Our ref: OUT23/12181

10 August 2023

Subject: Hunter Valley Operations North Continuation Project (SSD-11826681) and Hunter Valley Operations South Continuation Project (SSD-11826621) – Environmental Impact Statement – clarification of DPE Water advice

Figure 10 - Hunter River Paleochannel

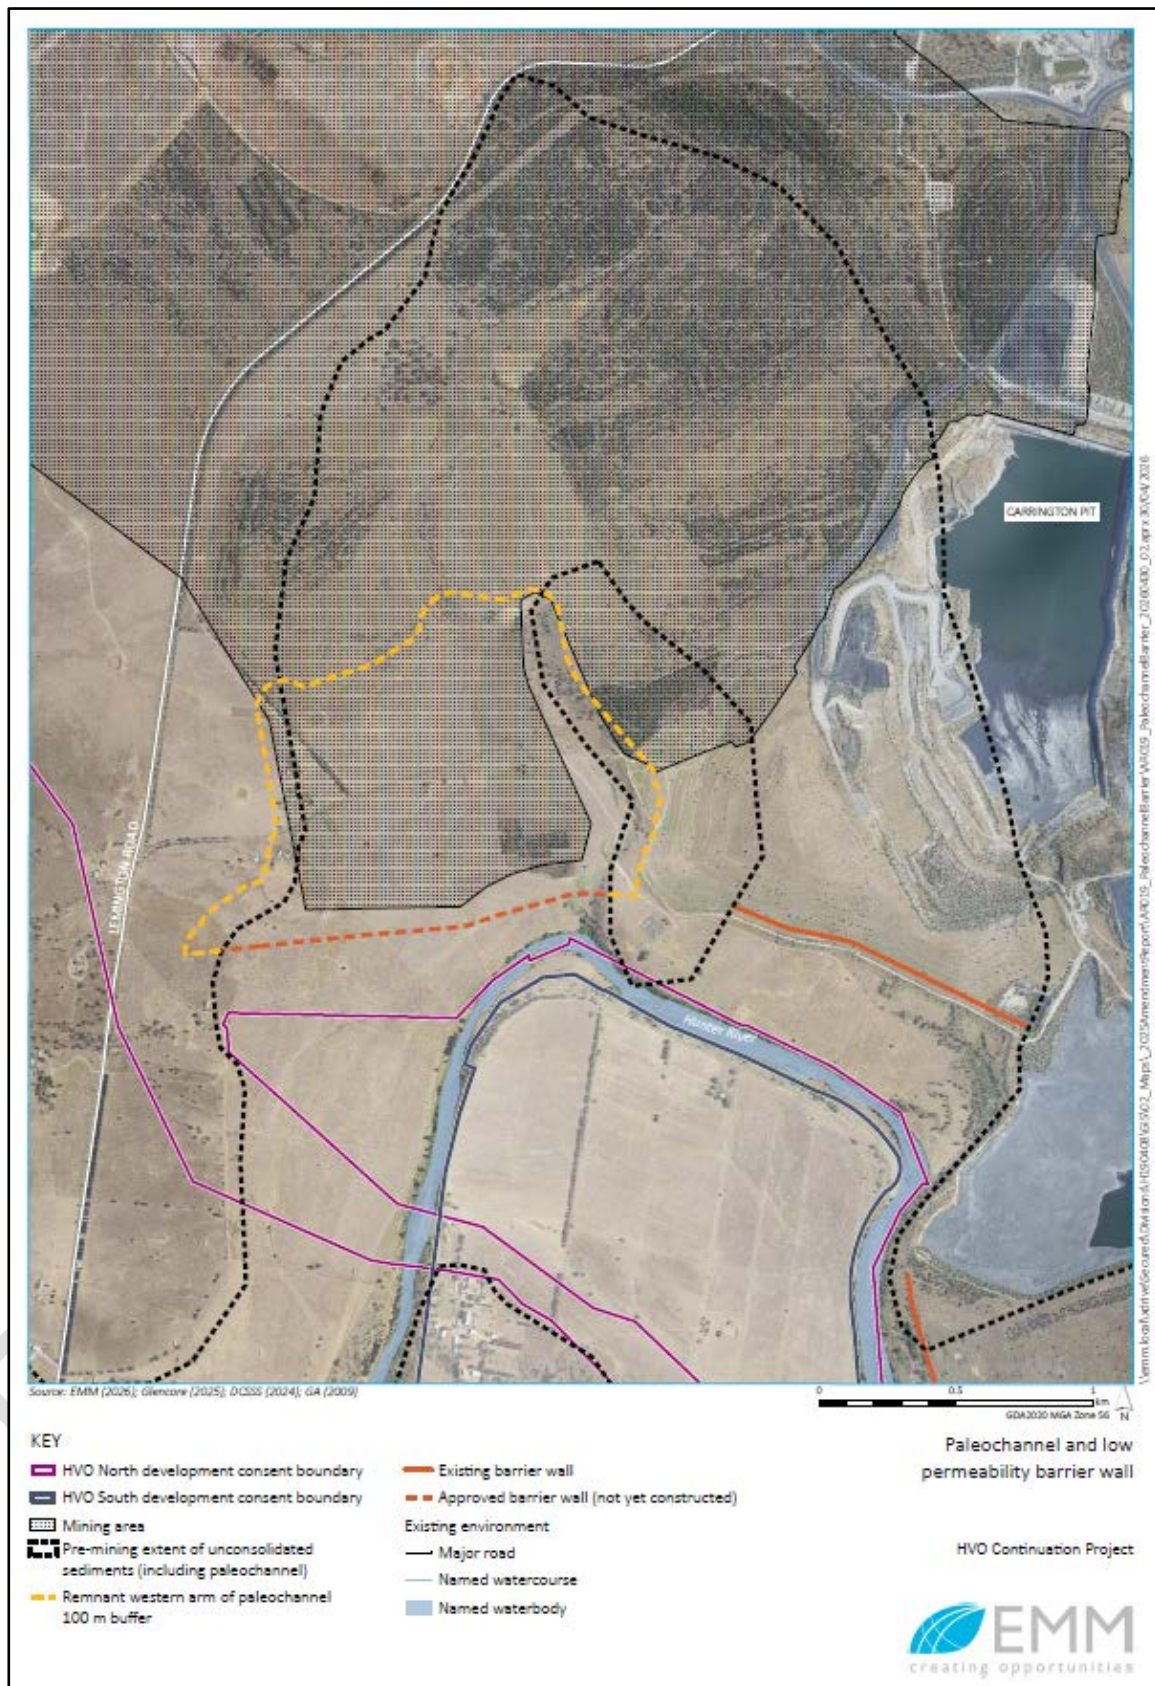
I refer to a meeting held on 25 July 2023 about the above matter and a request to clarify DPE Water's advice (OUT23/3591) on the Environmental Impact Statement in relation to the boundary that should be used for determining the setback distance from the Carrington West Pit, which was included as part of recommendation 2.1 of DPE Water's advice.

The intent of an option of a 150 m setback from the Hunter Regulated River Alluvial Water Source was for discontinuation of any mining in unconsolidated sediments, which would be inclusive of the paleochannel deposits. This would limit enhancing a hydrological connection from the Hunter River and associated alluvial aquifer with the HVO mining activities, negating the need to construct the West Carrington low permeability barrier.

DPE Water's recommendation of a 150 m setback from the Hunter Regulated River Alluvial Water Source applies at the boundary of the unconsolidated alluvial sediments and the hard rock material of the North Coast Porous Rock Groundwater Source.
